RE: 20 Cedarow Court – Site Plan Application Revision

As we discussed please find a list of changes to the approved site plan for 20 Cedarow Crt (Site Plan D07-12-19-0189).

Title  
STORM DRAINAGE PLAN

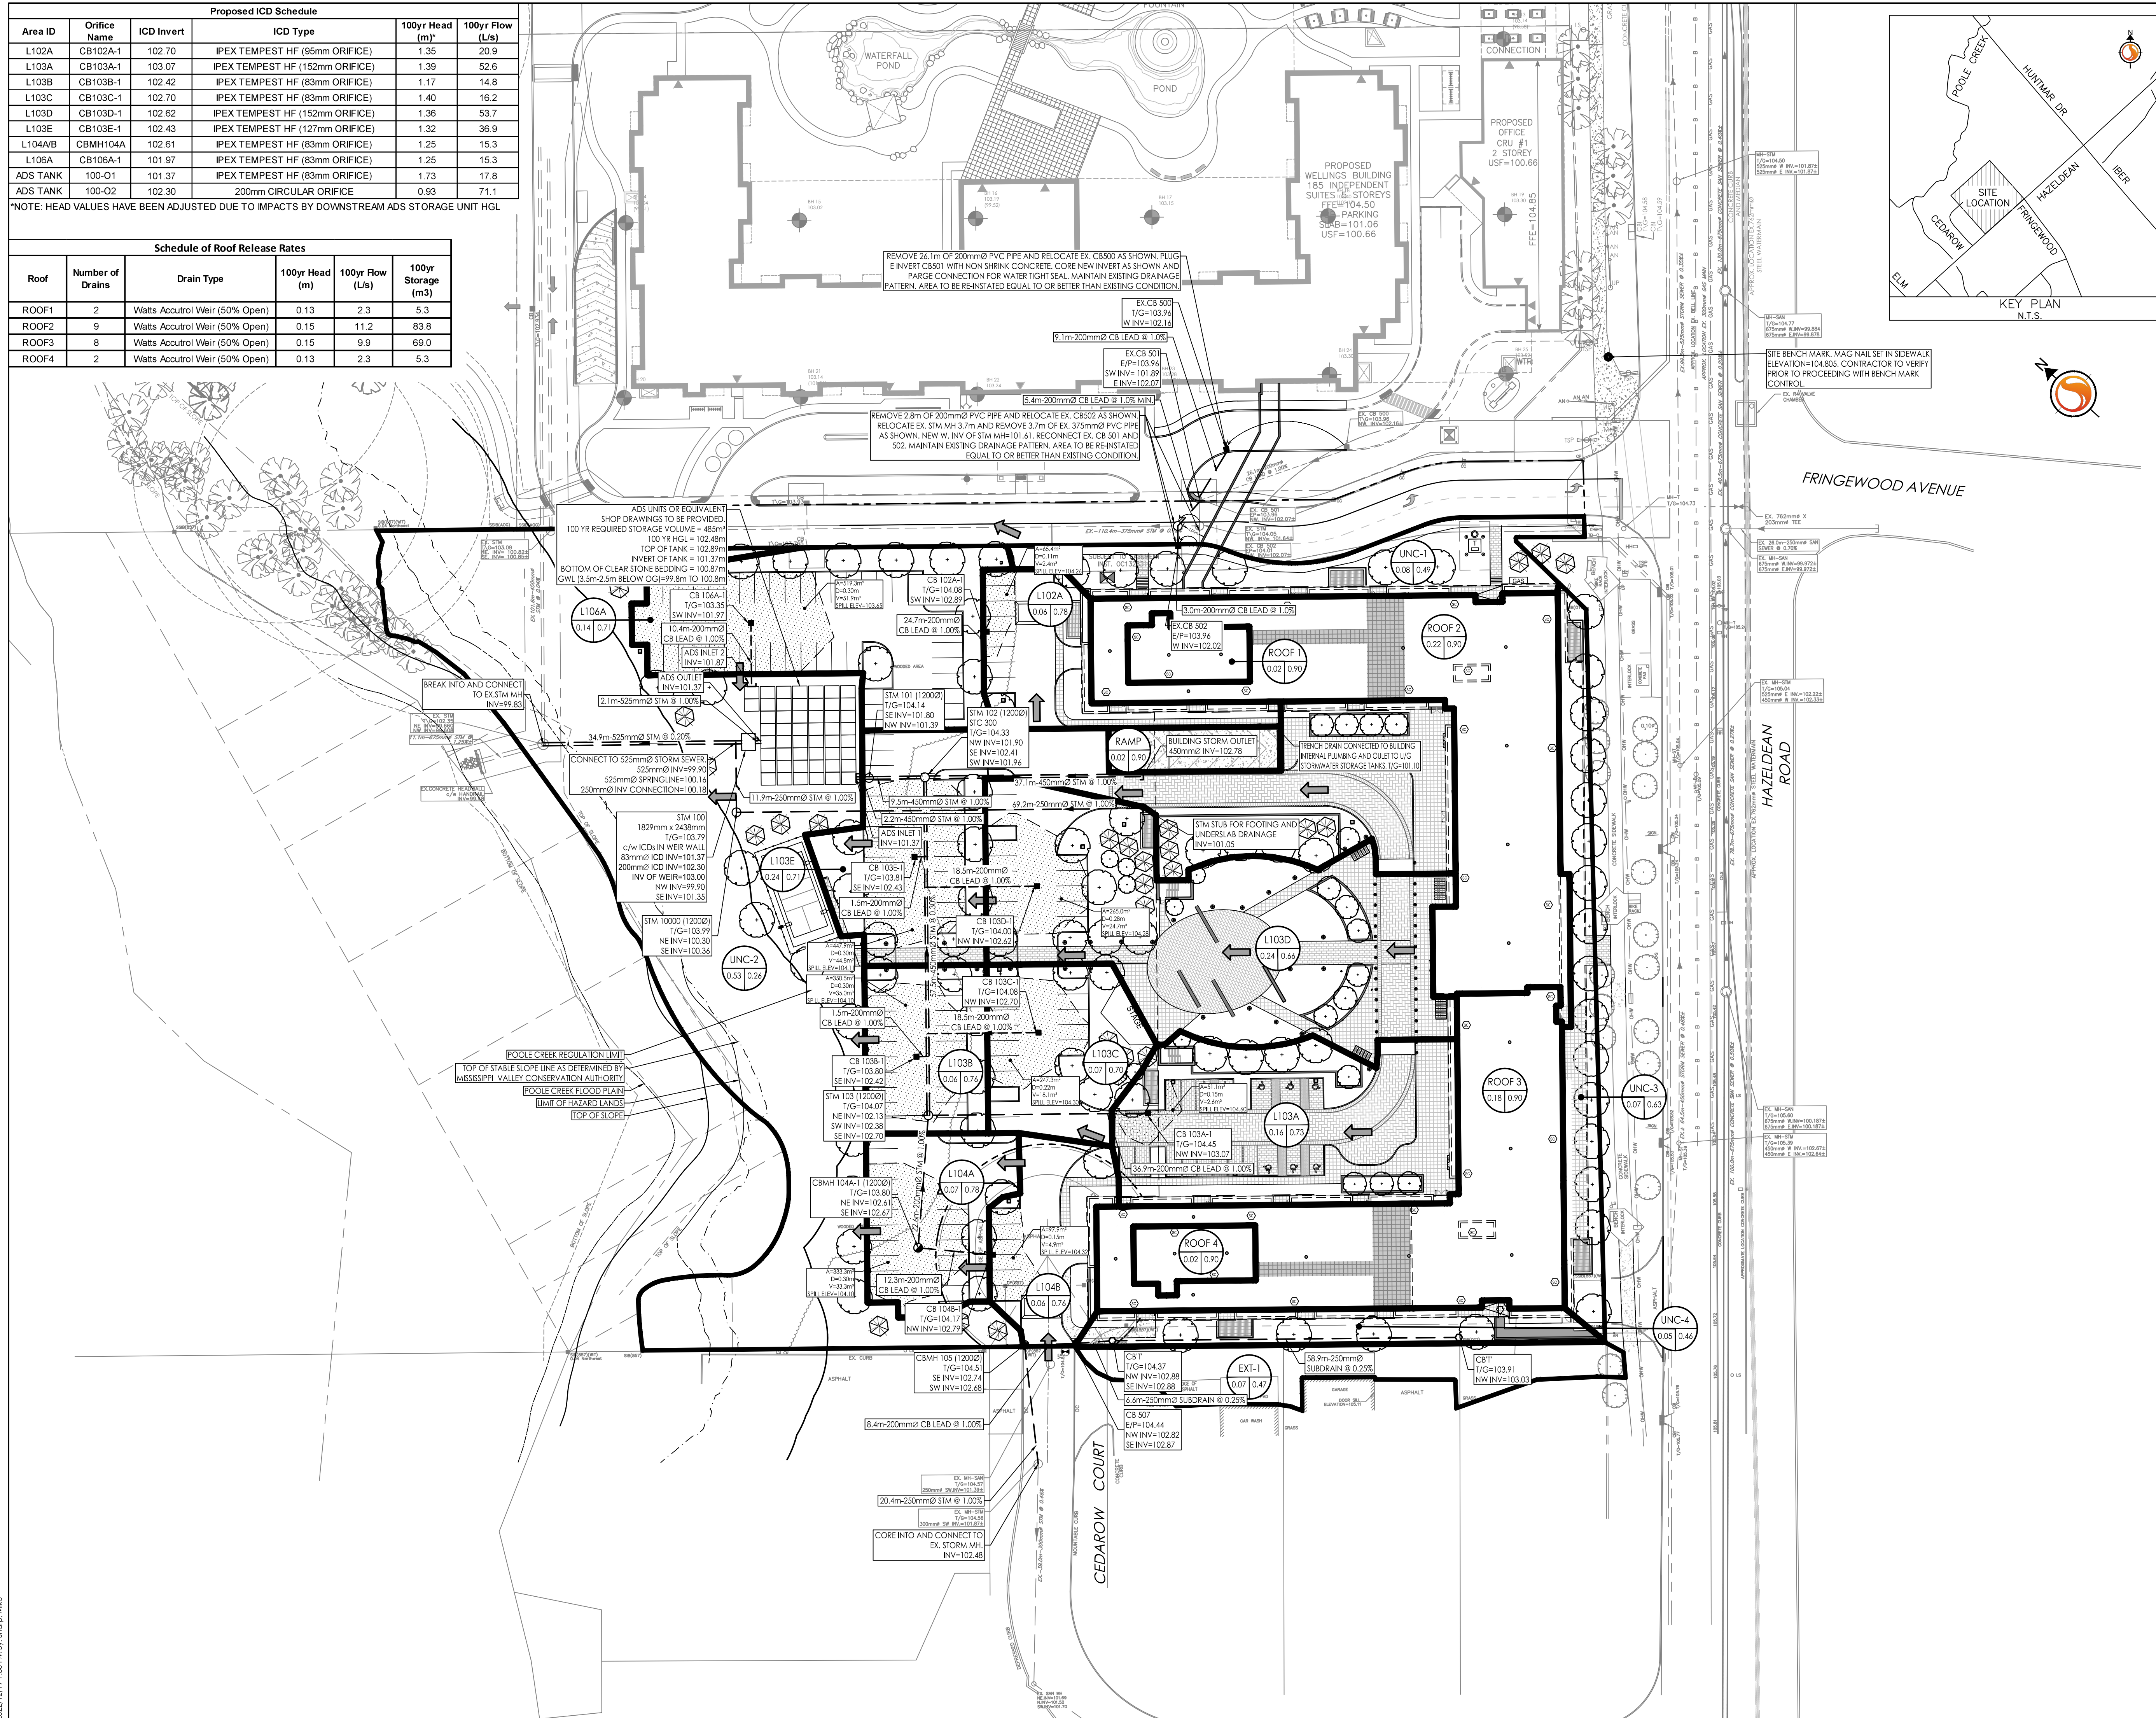
- a. Existing approved storm outlet still being utilized.
- b. Increase in proposed on-site storm sewers due to the removal of the phase 4 building being replaced with parking lot.
- c. Concrete stormwater management tanks have been replaced with ADS stormwater management system.
- d. Increased surface stormwater storage achieved with CB's and ICD's replacing the phase 4 roof top stormwater storage with the additional parking lot area.
- e. No external stormwater (roof top exception) is being routed through the building mechanical storm sewers due to a significant reduction in the U/G parking structure and the ability to install a private storm sewer network.
